Albuquerque  
Metropolitan  
Arroyo  
Flood  
Control  
Authority

December 4, 2003

Re: Grading & Drainage Plan Details for Tract 14A and 14B, Black Ranch, ZAP B-14  
Cottonwood Crossing, Phase 2, Engineer's Stamp Dated October 21, 2003

GRADING AND DRAINAGE PLAN

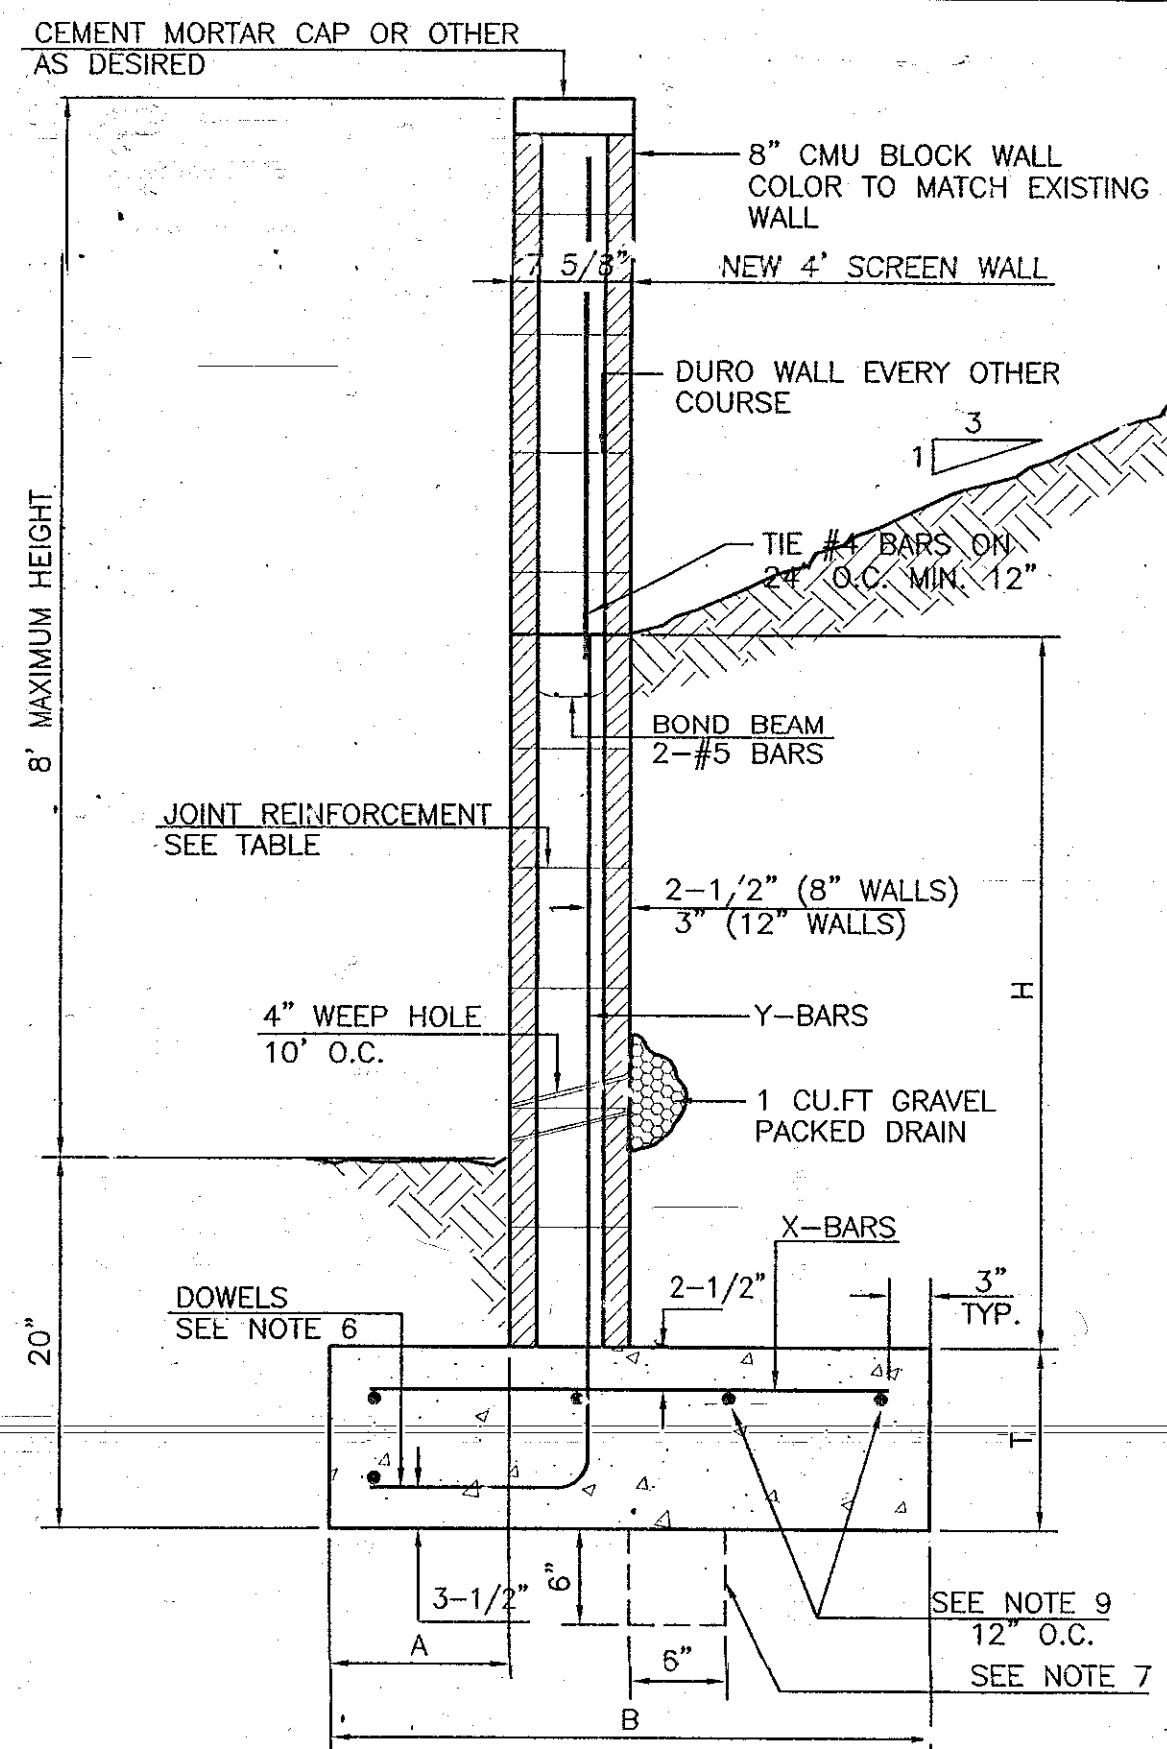
1. The retaining wall adjacent to the detention pond should be constructed prior to the placement of the slope paving.
2. Pond seepage may undermine the existing shotcrete on the Corrales Main Canal. Therefore, AMAFCA will require a geotechnical report. The report should also analyze foundation treatment.
